MMC Garage Plans - Site/Public ROW Comments

Good afternoon, Nell. The following are my comments on the latest submittals by MMC for the St. John Street Parking Garage, PL-207-2018:

CIVIL DETAILS - 3

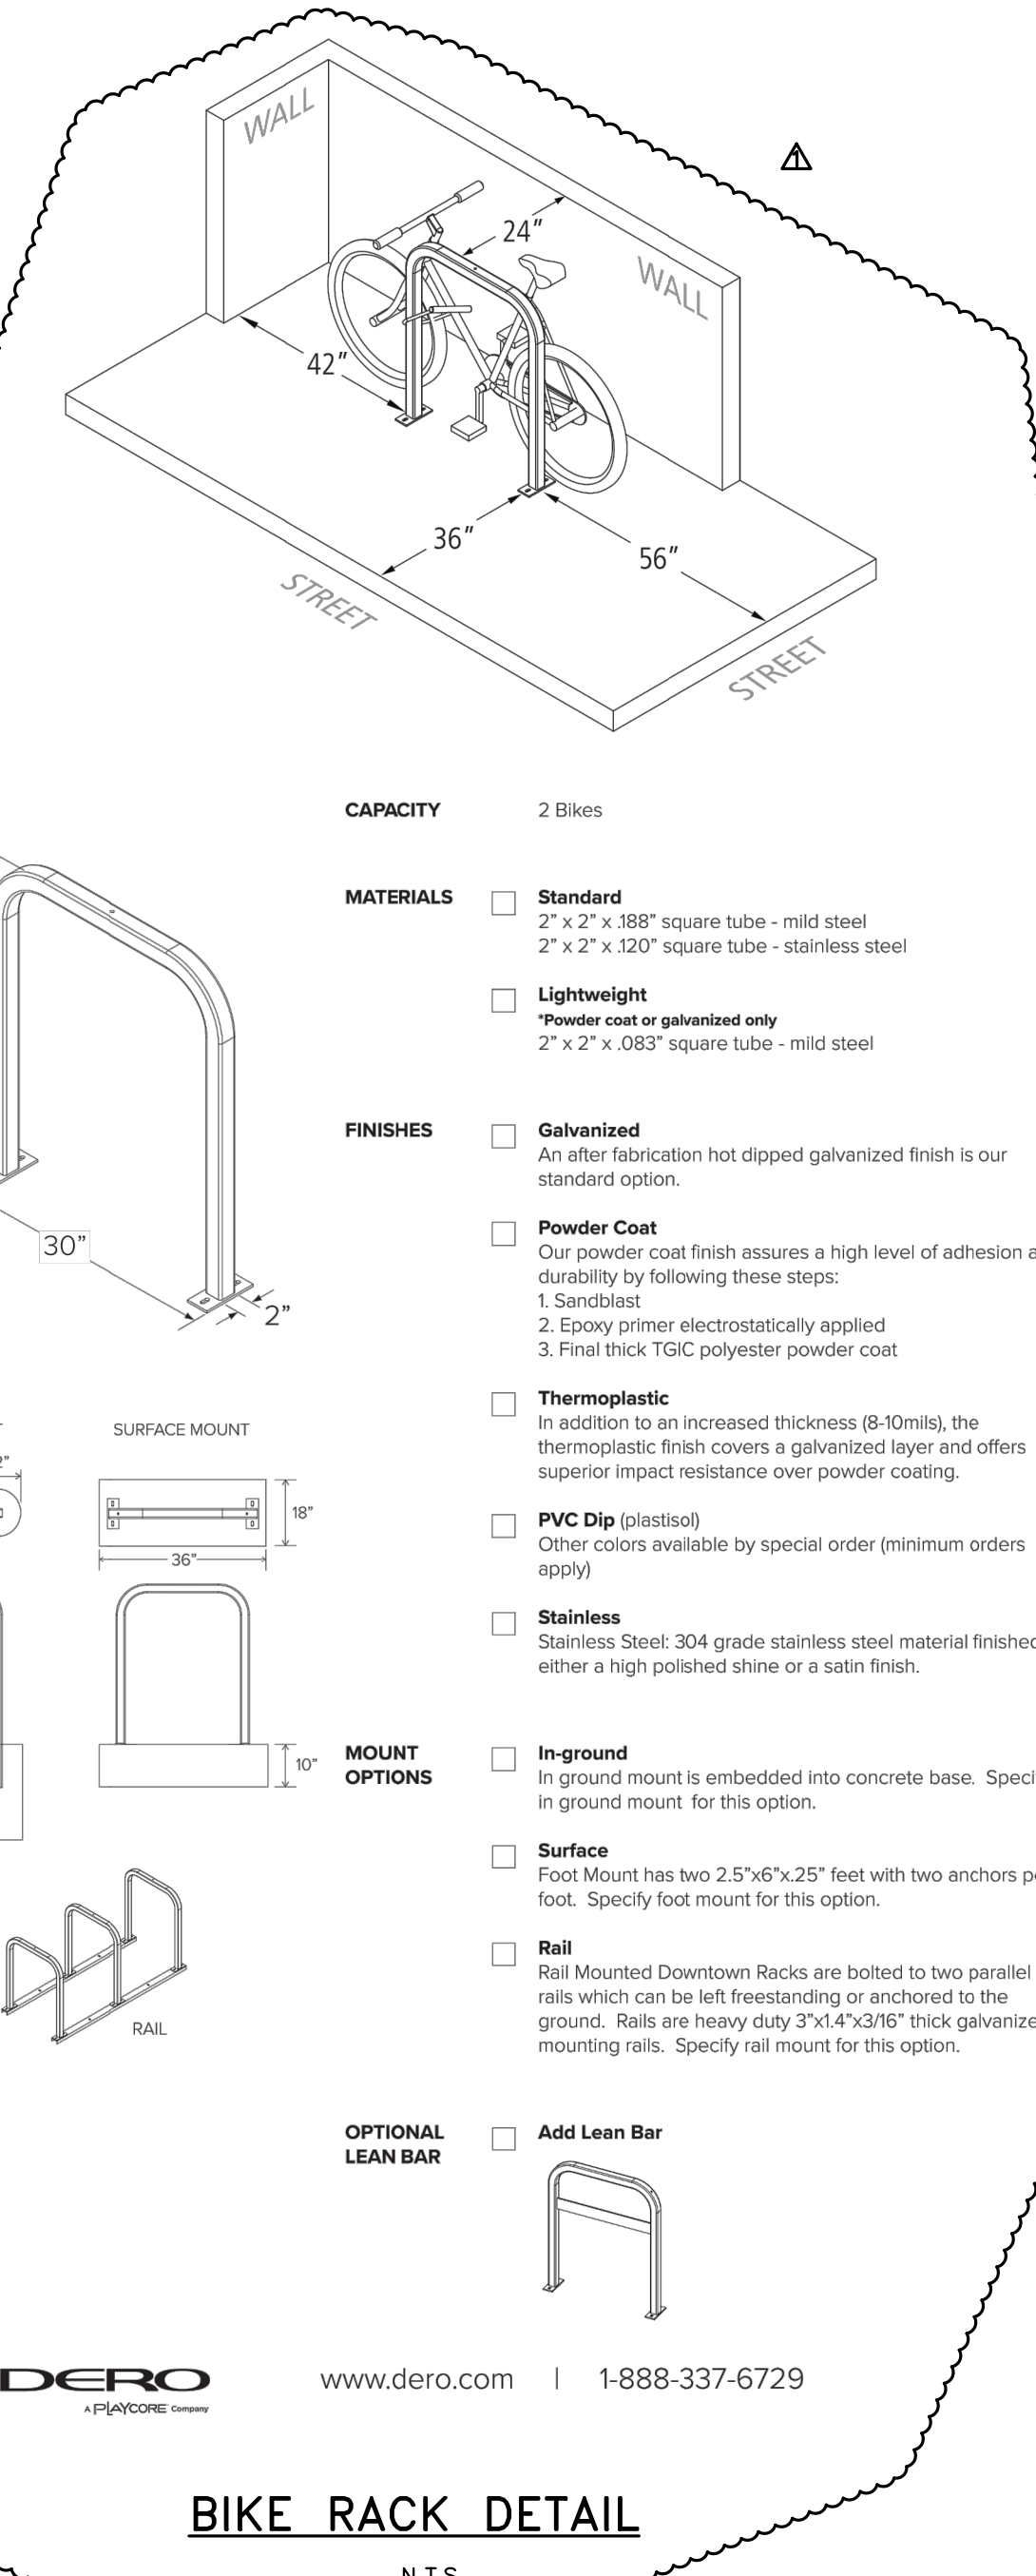
- Brick Sidewalk Detail - change to "2% cross slope (**MAX**)" (not typ.)
- Cast In Place Concrete Sidewalk - add "2% cross slope (MAX)"
- Sidewalk Detectable Warning Panel - change to current detail with **concrete border** (not brick)
- I do not see (may have missed it) a Brick Driveway Detail - additional gravel base (2"+) should be added (to brick sidewalk detail amount) and 2% MAX cross-slope needs to be indicated as well as 1' bituminous strip with 1" reveal at street edge

1 | ELECTRICAL AND LIGHTING SITE PLAN
SCALE: 1" = 20' - 0"

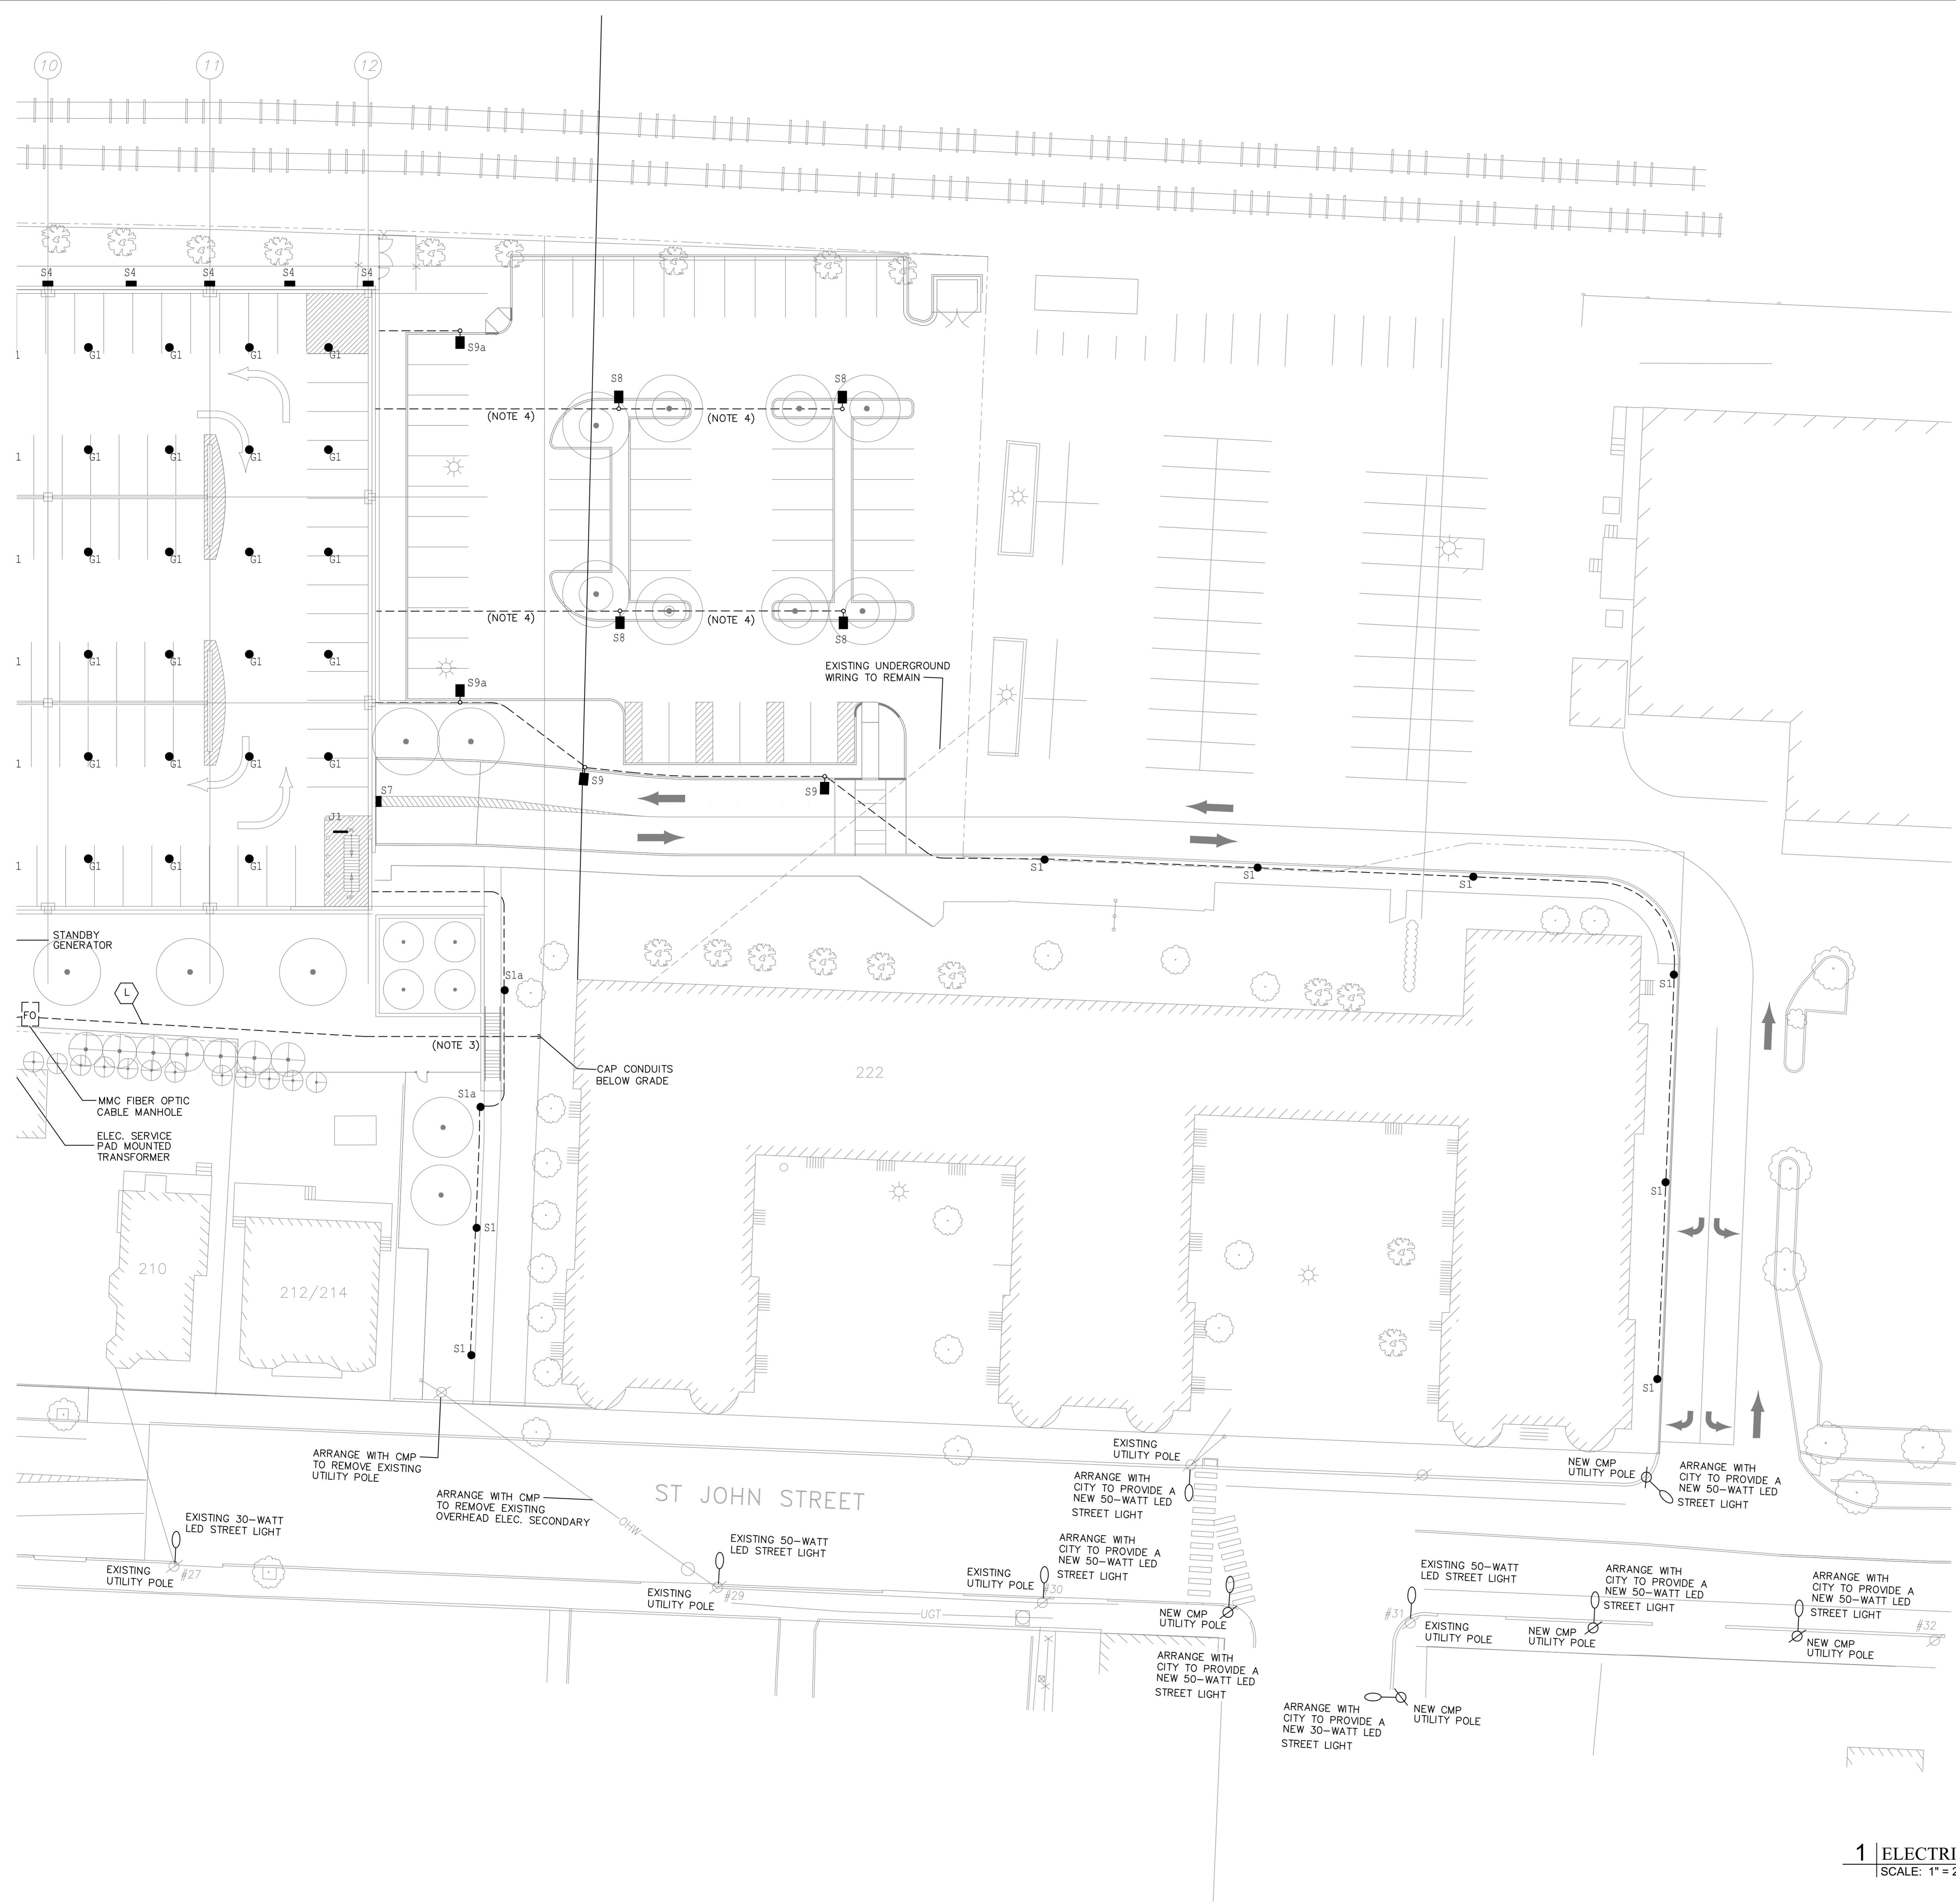
- It is not my understanding that the City is providing the LED cobra head lighting as indicated in Note 8 - I believe it is the applicant that is to provide it
-
